BLACK SLUICE INTERNAL DRAINAGE BOARD

Planning Application No SH/0984/11: Two storey extension & alterations at Random Cottage, Beck Bank, West Pinchbeck, Spalding, Lincolnshire, for Mr & Mrs N A Clark

The Board has received the above planning application and has the following comments:

DRAWING NO:
WEN/1460/11/01A

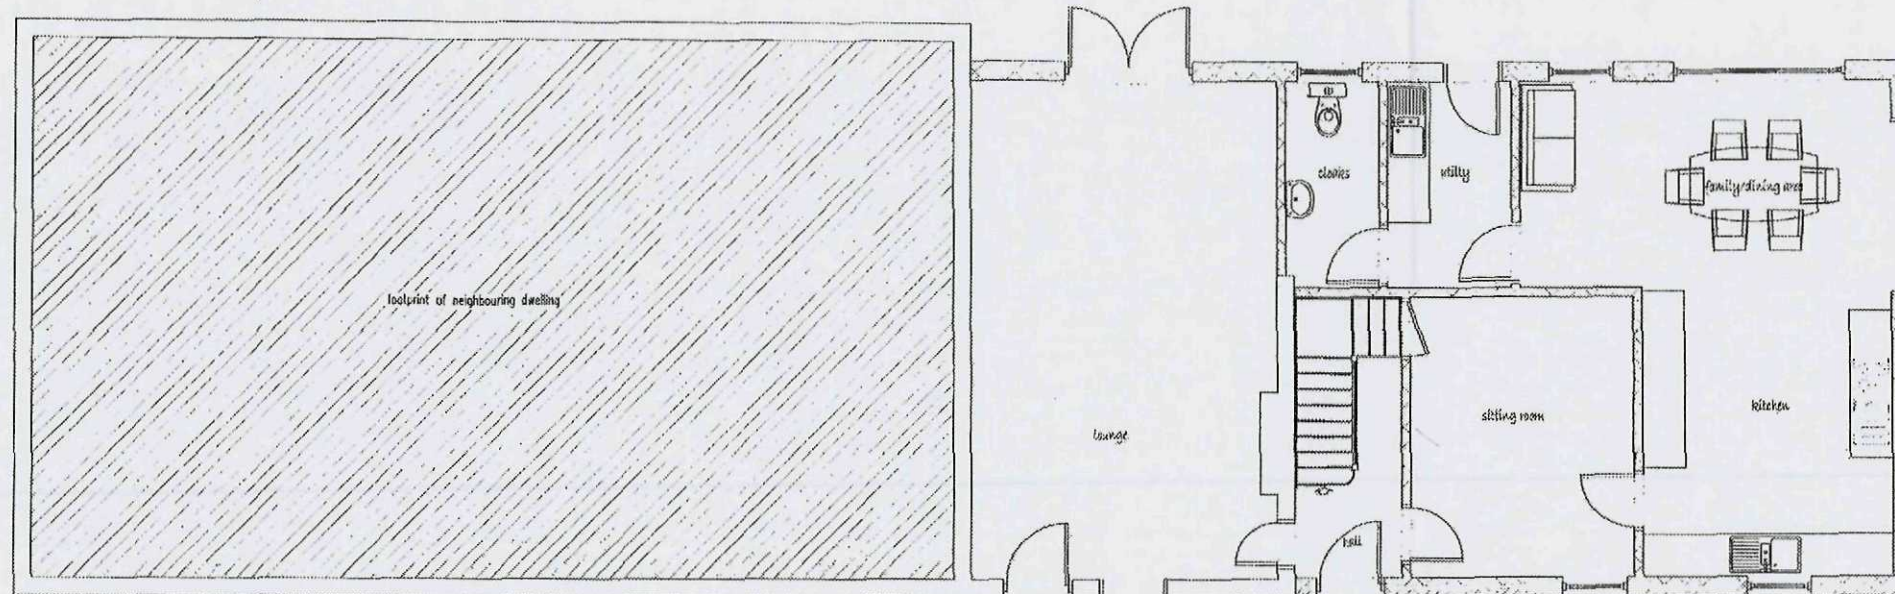
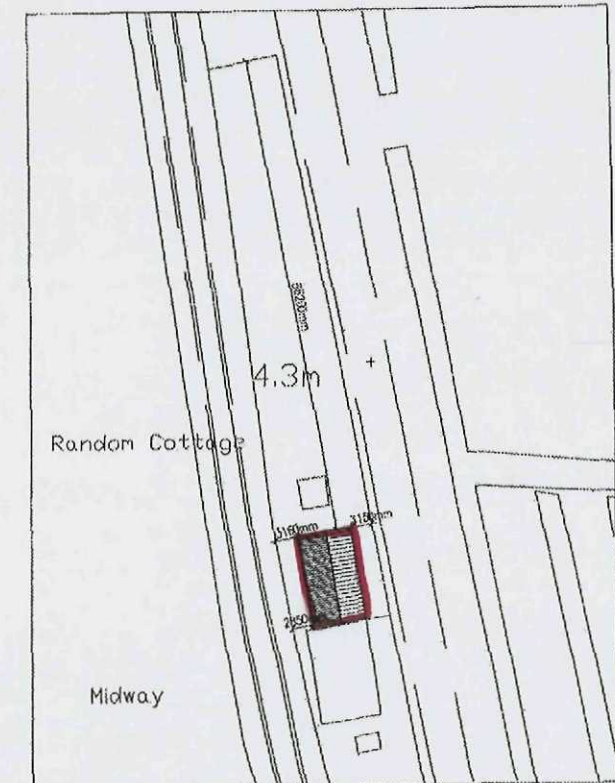
The watercourse on the western boundary of the plot/development is a Board Watercourse. Whilst it is acknowledged that parts of the existing building are within the Boards byelaw distance, and as such have unofficial historical consent, the proposed alterations will extend the building closer to the watercourse and will therefore require formal consent. The applicant has made a formal application, and this will go before the Board at its next meeting on the 8th February 2012.
